Rezoning Transportation Analysis

Petition Number: 2022-134

Date	Description
01-26-23	First Review (PDM)
02-22-23	Second Review (JP)
03-17-23	Third Review (JP)
03-29-23	Fourth Review (PDM)

Sheet  
**RZ3.0**

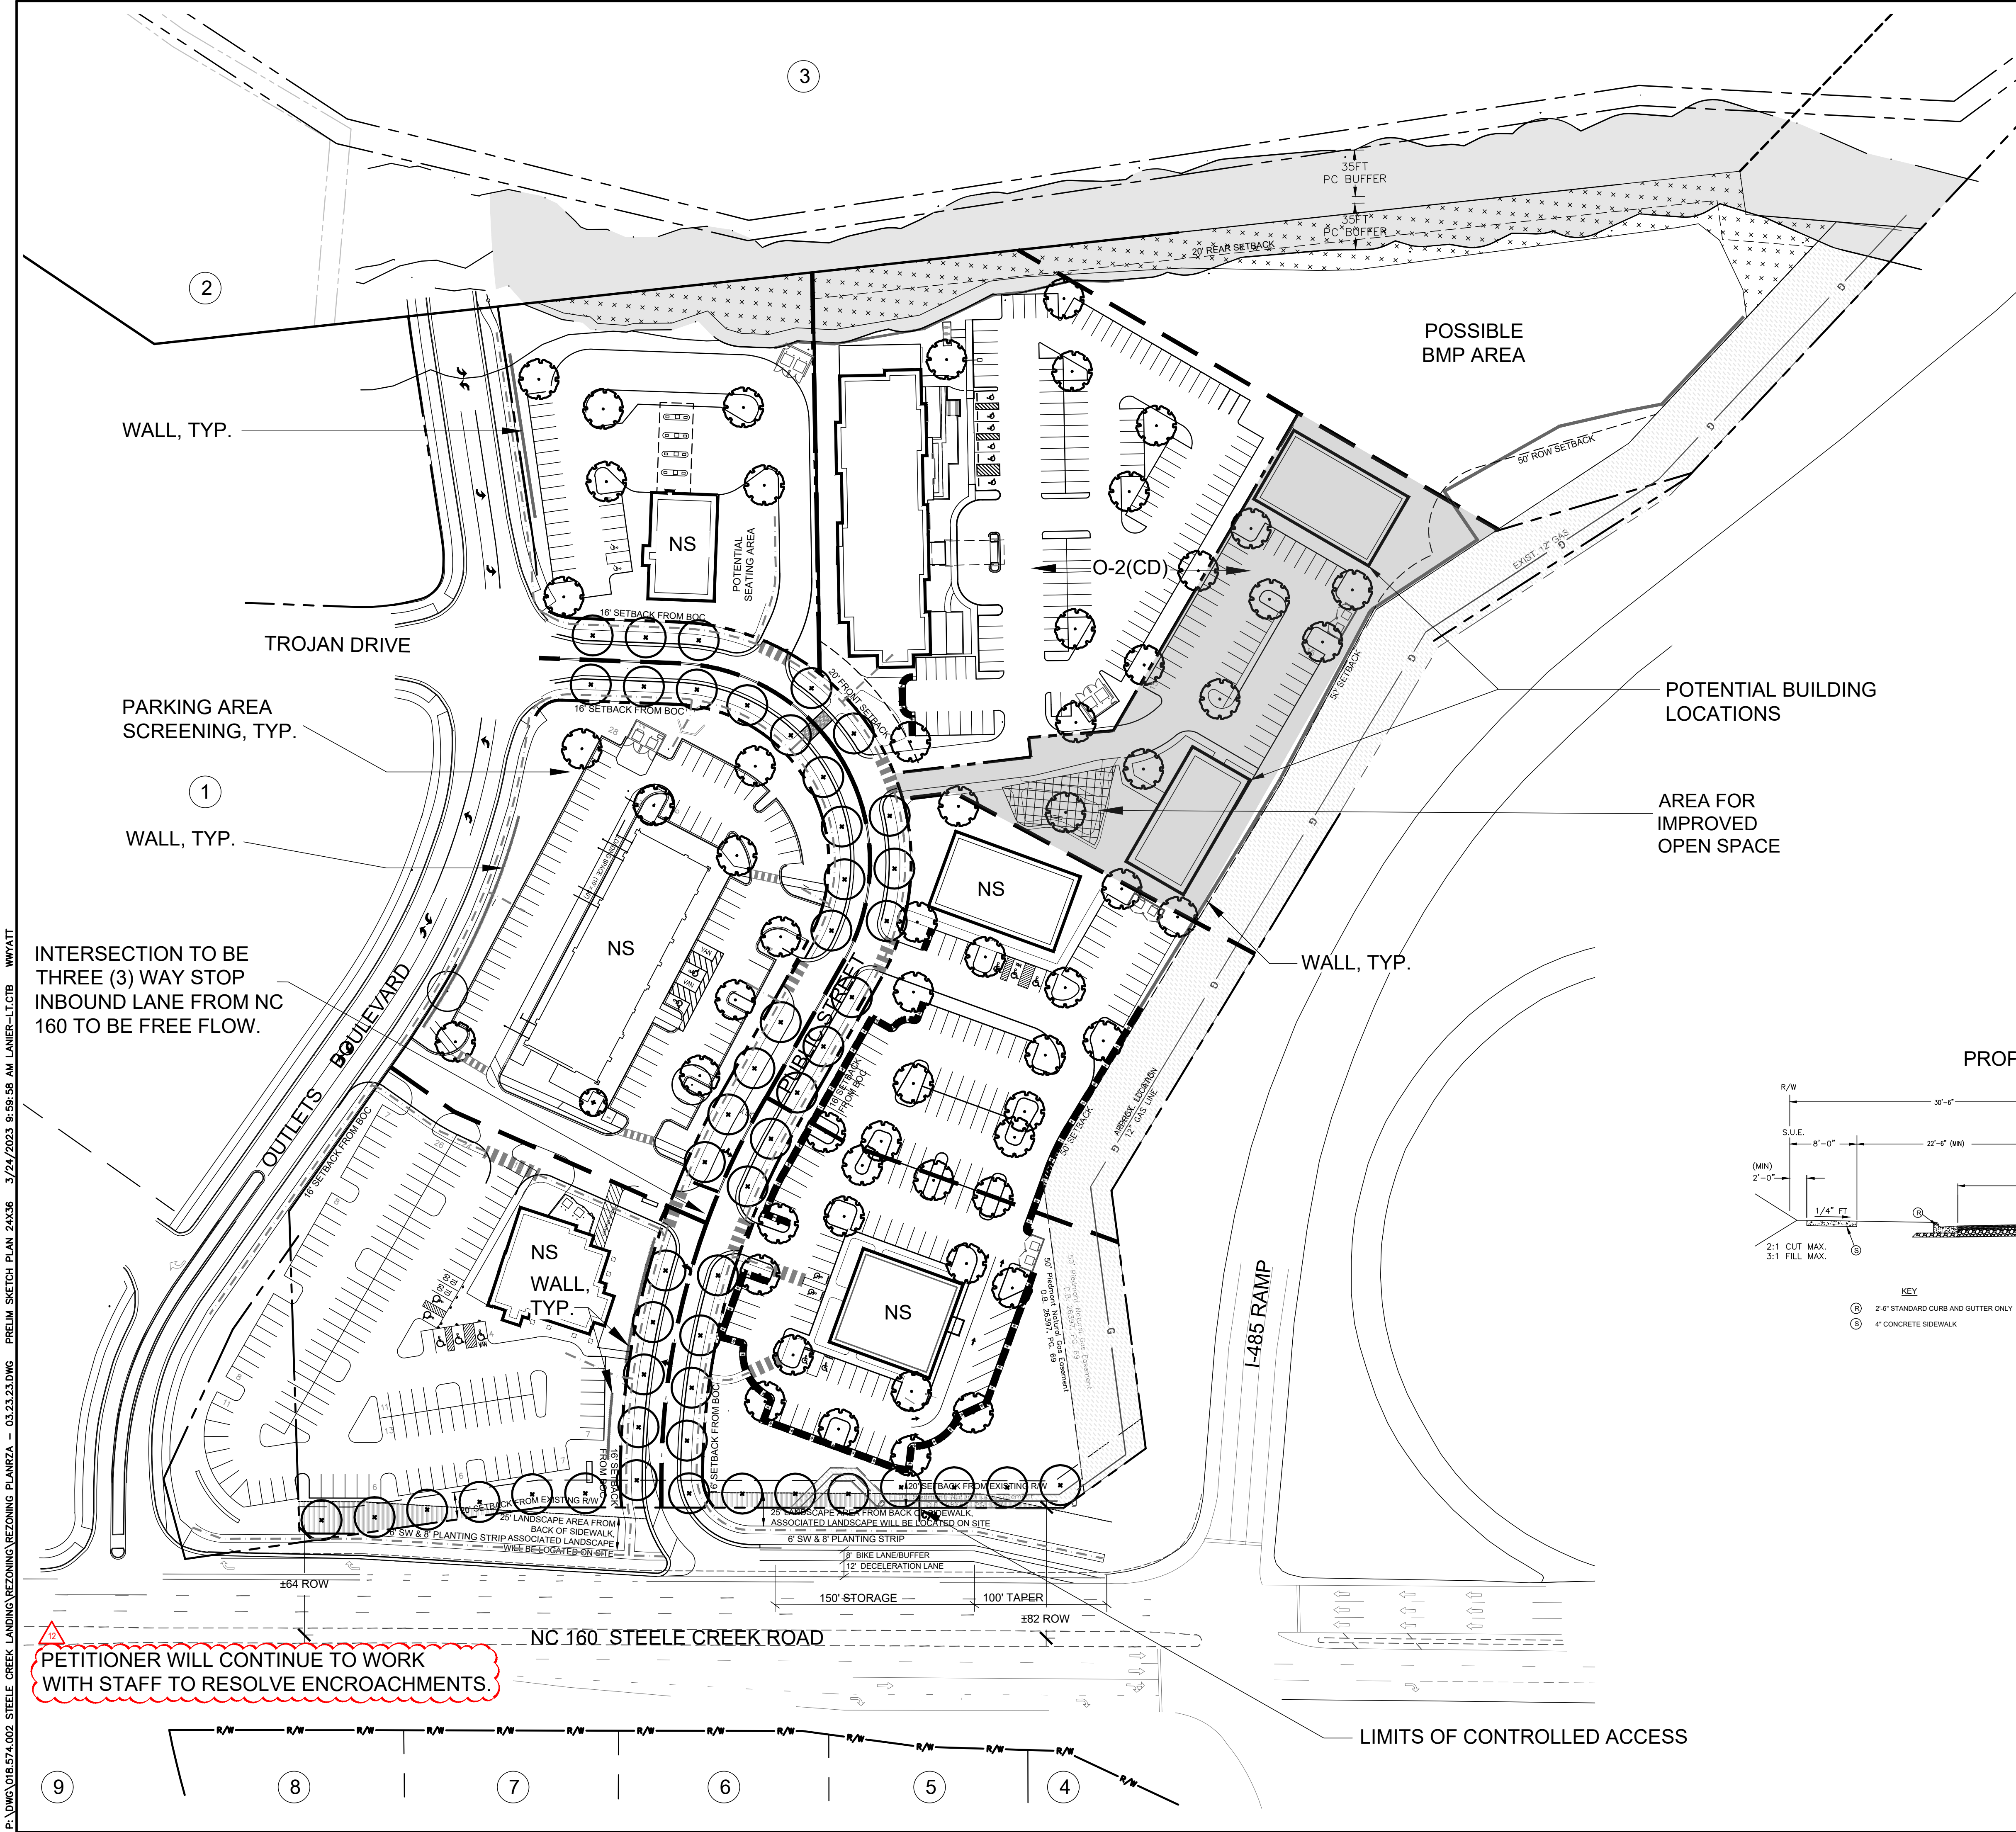
8. **Outstanding Comment 3-17-23:** Revise site plan and add conditional note to install curb and gutter along the Steele Creek frontage between Outlets Boulevard and Trojan Drive.
